From: Kate Giddings <kate.giddings@arun.gov.uk>
Sent: 07 May 2021 12:50
To: Maria Tomalova <Maria.Tomalova@arun.gov.uk>
Cc: Planning.Responses <Planning.Responses@arun.gov.uk>
Subject: FP/90/21/PD - 23a Felpham Road, Felpham, PO22 7DA

In relation to the above application, please may EH comment as follows:

Drg. no. 2017/02 Sept. 2020
O'NEILL ARCHITECTURAL SERVICES
Tel: [01243] 531333

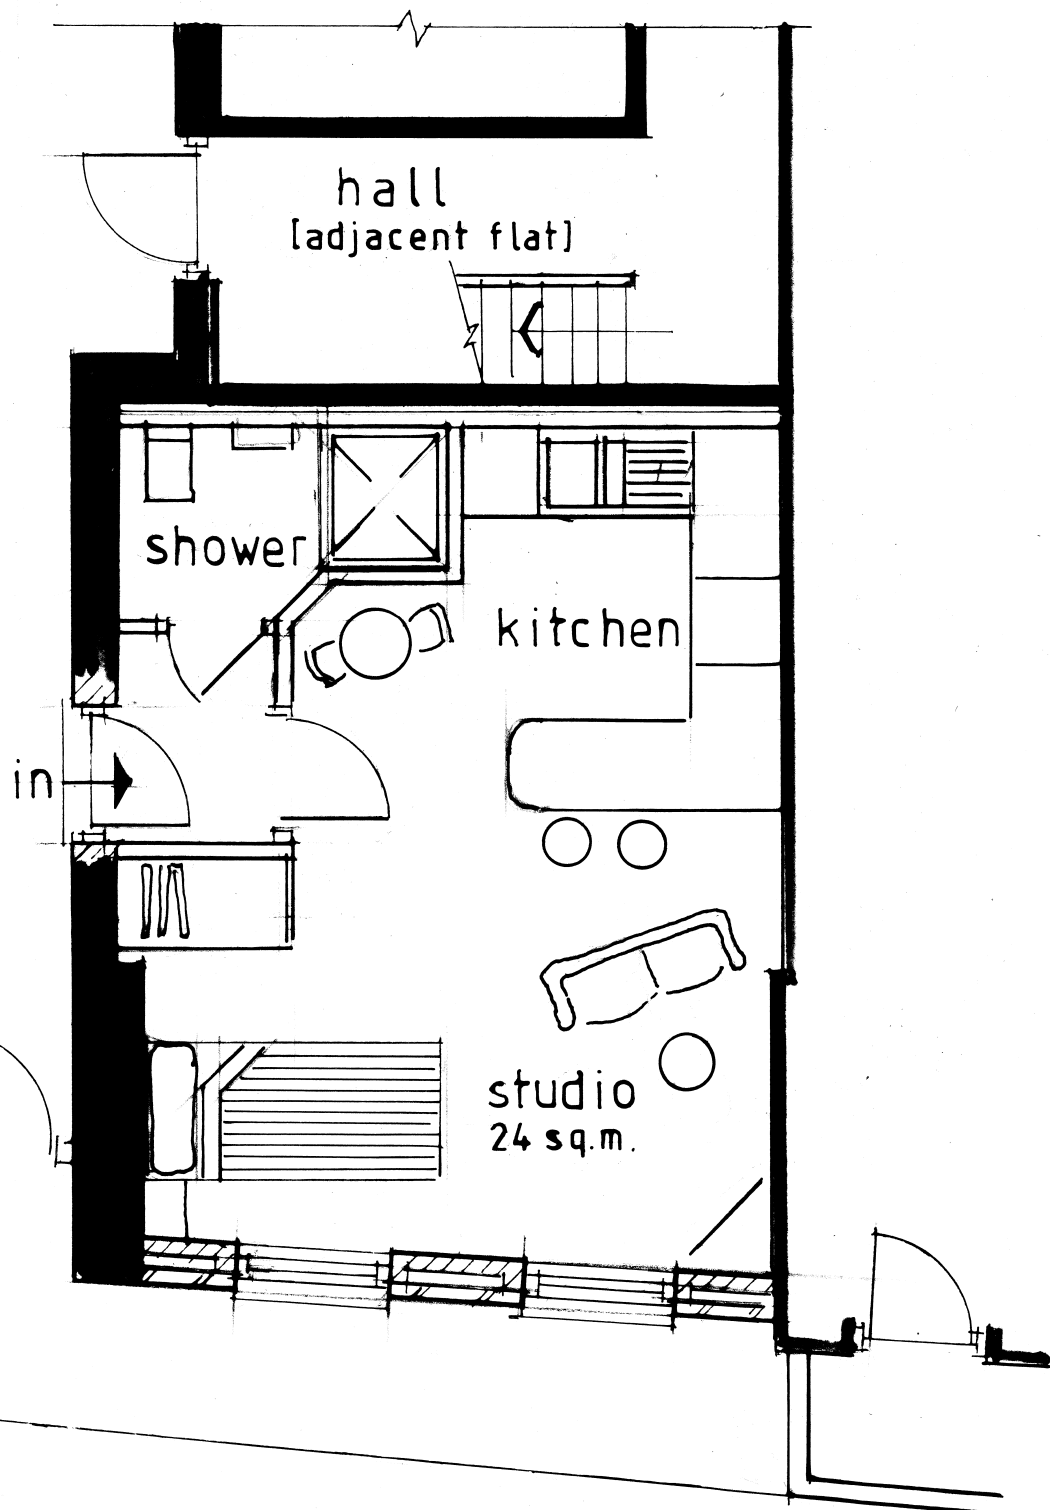
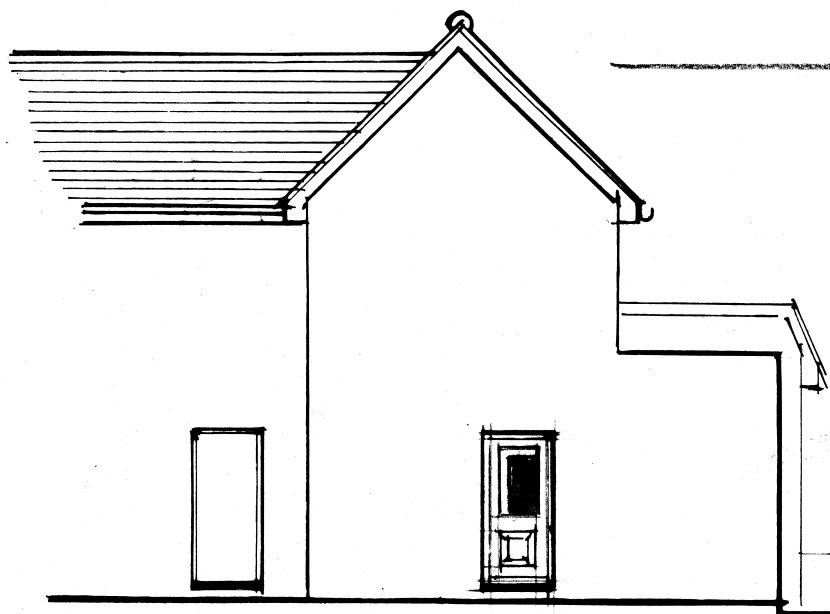
- The sound insulation of the walls between the subject property and the neighbouring residential unit(s) shall achieve a minimum airborne sound insulation value of 48 dB ($D_{nT,w} + C_{tr}$). Prior to occupation of the proposed residential unit, a test to demonstrate compliance with this level shall be undertaken by a competent acoustician and submitted to and approved in writing by the Local Planning Authority. **Reason:** To protect the amenity of local residents in accordance with Policy QE SP1 of the Adopted Arun Local Plan 2011 – 2031

In addition to the above, please may the applicant advise where the kitchen extract system will be routed (including where it will terminate and any proposed outlet features, e.g. vents, baffles, cowls, etc.) and how noise, vibration and odour emissions will be managed.
